Recommendation Report for Planning Permission for Works or Extension to a Dwelling

REF NO: FG/1/26/HH

LOCATION: 8 Laburnum Close
Ferring
BN12 5EJ

PROPOSAL: Proposed front extension (to replace existing porch/conservatory), rear extension, new roof tiles and render to cover existing brickwork and loft conversion to include front and rear dormers and removal of barn hips to the side.

Drawing Number: AR-201-03 Revision: Revision

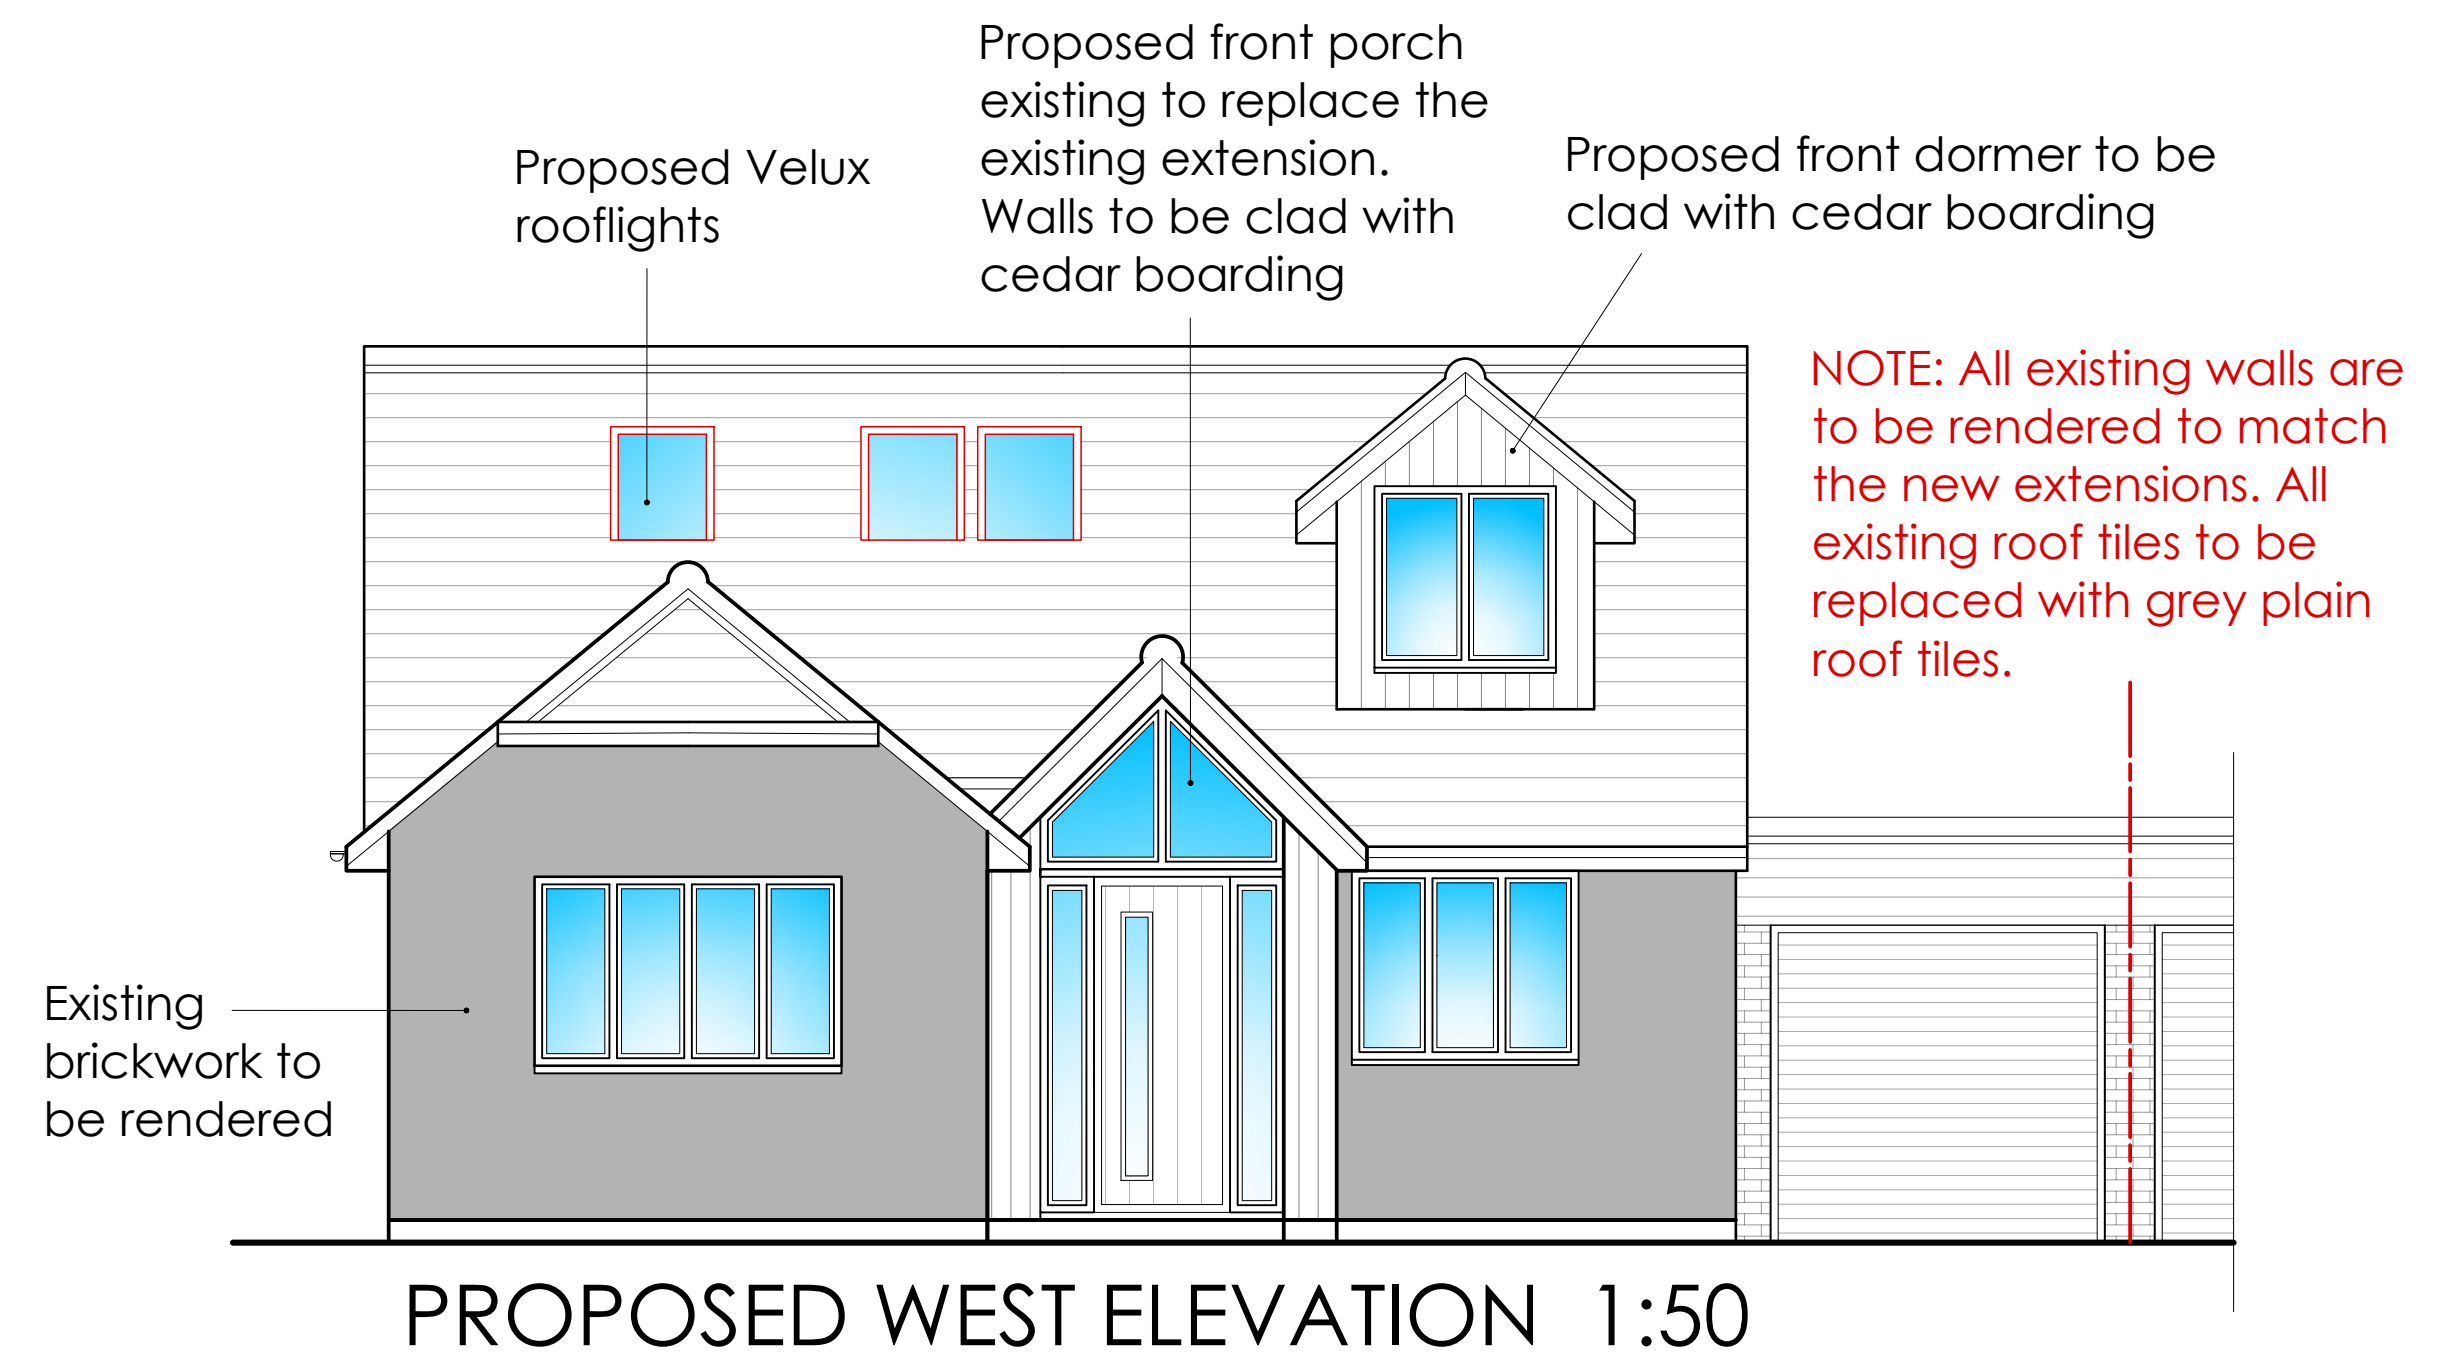
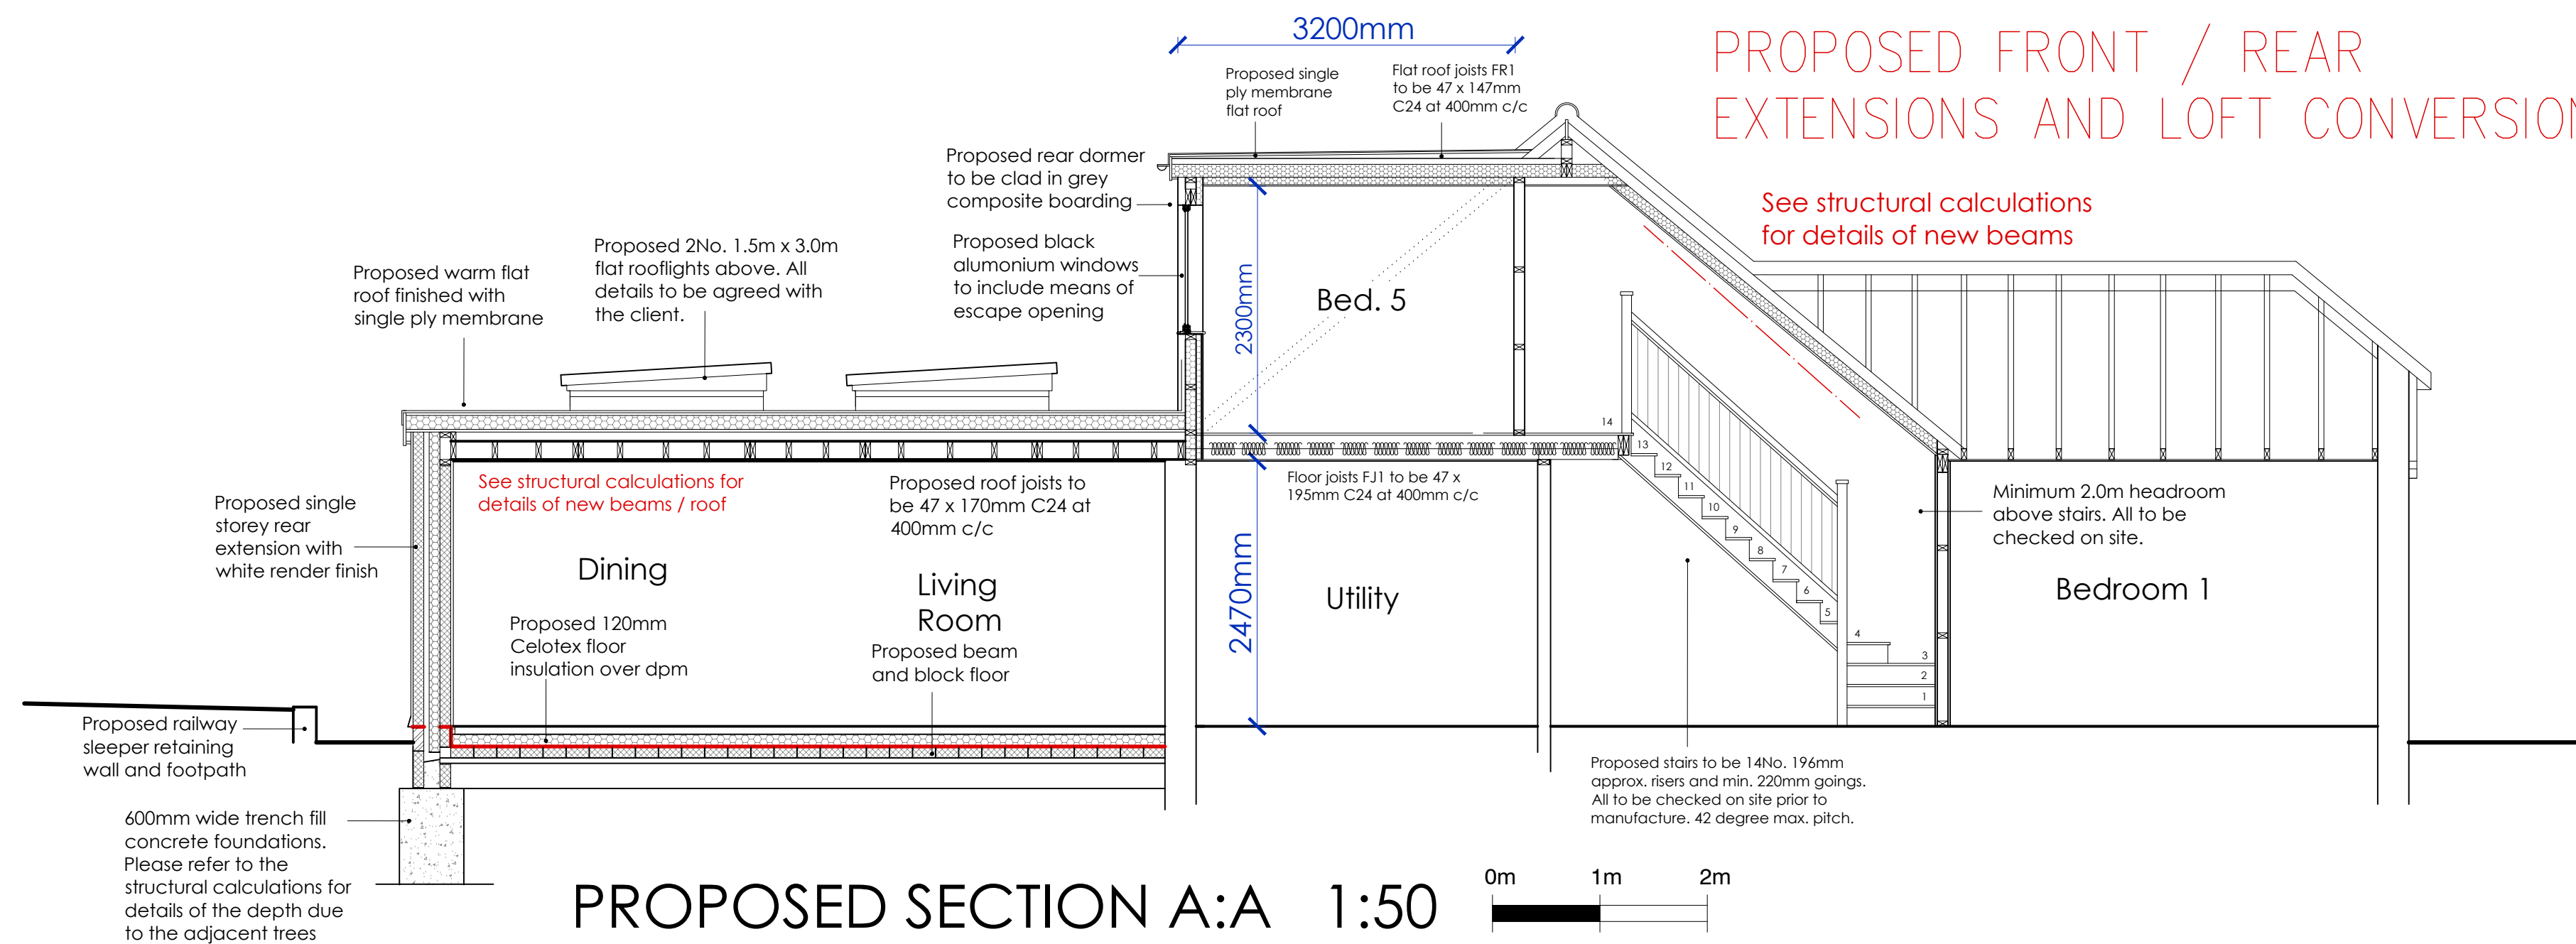
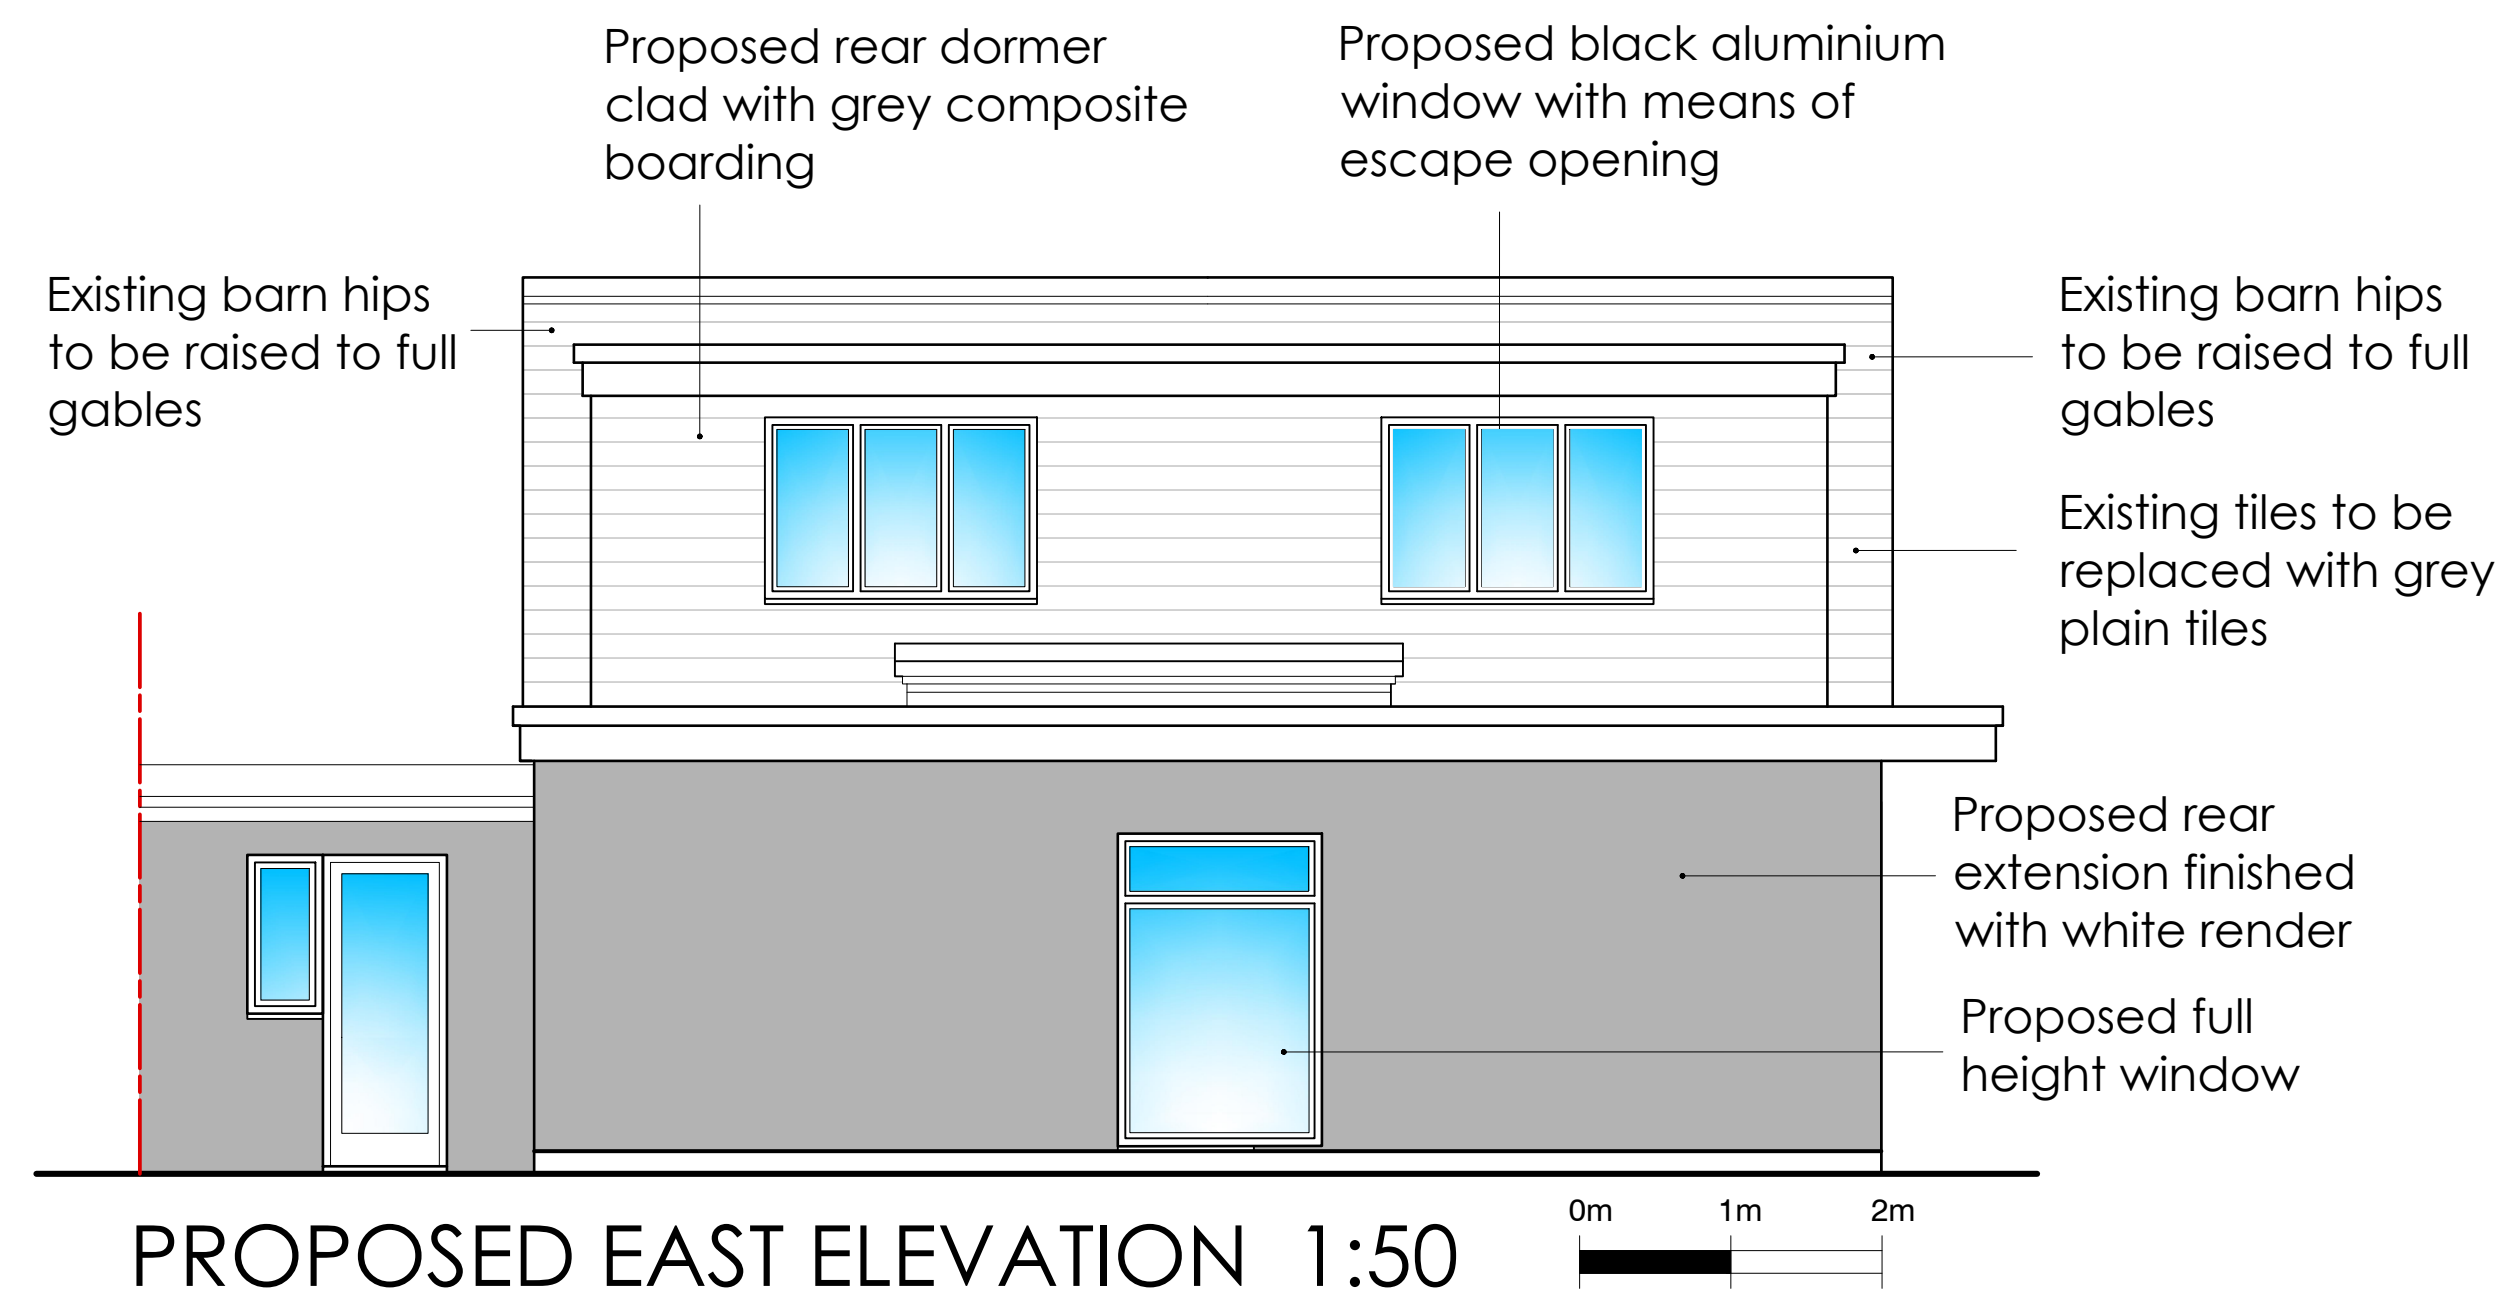
Roof alterations are proposed to convert the loft to habitable space. The existing barn-hipped roof sections would be raised to full gables, aligning with the existing ridge height of 5.9m (from existing eaves height of 4.4m at the barn-hip ends). New dark grey roof tiles are proposed. It is noted that there are no other properties with gabled roof forms within the street scene, however, this alteration could be constructed under permitted development, and it is acknowledged that there is some variation within the street scene with regards to hipped and barn-hipped roof forms. As such, the proposed roof extensions would not result in demonstrable harm to visual amenity.

A small front dormer is proposed on the front (west) elevation, featuring a pitched roof consistent with the existing front projection and new front extension. The dormer would measure approximately 1.7m in width and 2.9m in depth, with a maximum height of 2.3m and an eaves height of 1.1m. It would be finished in cedar boarded cladding and contain a two-pane window. The dormer would be a subservient addition to the front roof slope, and would not appear overly dominant despite there being no other examples within the street scene. As such, given the scale and design of the dormer, the dormer would be acceptable within the context of the site.

A rear dormer is proposed within the rear roof slope elevation, facing east. The dormer would measure approximately 8.2m in width and 3.3m in depth, with a flat roof reaching 2.4m in height. It would be finished in grey composite cladding to complement the proposed roof tiles and would feature two three-pane windows. The rear dormer would be large in scale, and would not be subservient addition within the rear roof slope. The eaves line of the original roof would not be reinstated, and the proposed dormer would instead adjoin the flat roof section of the rear extension. However, it is noted that a rear dormer of comparable scale and volume could be constructed under permitted development, and given the siting of the dormer to the rear, the dormer would not result in demonstrable harm to visual amenity.

External materials and finishes would include cedar board cladding to the proposed front dormer and front extension, with white render to the remainder of the host dwelling. While these materials would not reflect the existing character of the property or the wider street scene and therefore would not fully comply with the ADG, there is some variation within the street scene, with render present and a small proportion of the dwelling would comprise cladding. As such, the material change would not result in undue harm to visual amenity and would be acceptable in this instance.

Windows within the side (south) elevation would be at ground floor level and benefit from screening by the existing 1.8m high boundary fence. These openings would therefore not result in overlooking or loss of privacy to the neighbouring property to the south. The ground floor rear fenestration would look onto the private rear garden and would be adequately screened by the existing boundary treatment and mature vegetation. The new ground floor side facing openings on the northern elevation would not result in any harmful overlooking or loss of privacy due to the significant separation distance, reinforced by the presence of a public footpath and a 1.8m high boundary fence.

At first-floor level, the proposed dormer in the rear (east) elevation would introduce new openings that would provide some views of neighbouring gardens, and as such, would result in some degree of overlooking. However, due to the positioning of the dormer, the windows would not directly overlook any habitable room windows of the neighbouring property. In addition, a dormer of this scale could be constructed under permitted development, and the proposed dormer would not therefore result in unacceptable overlooking.
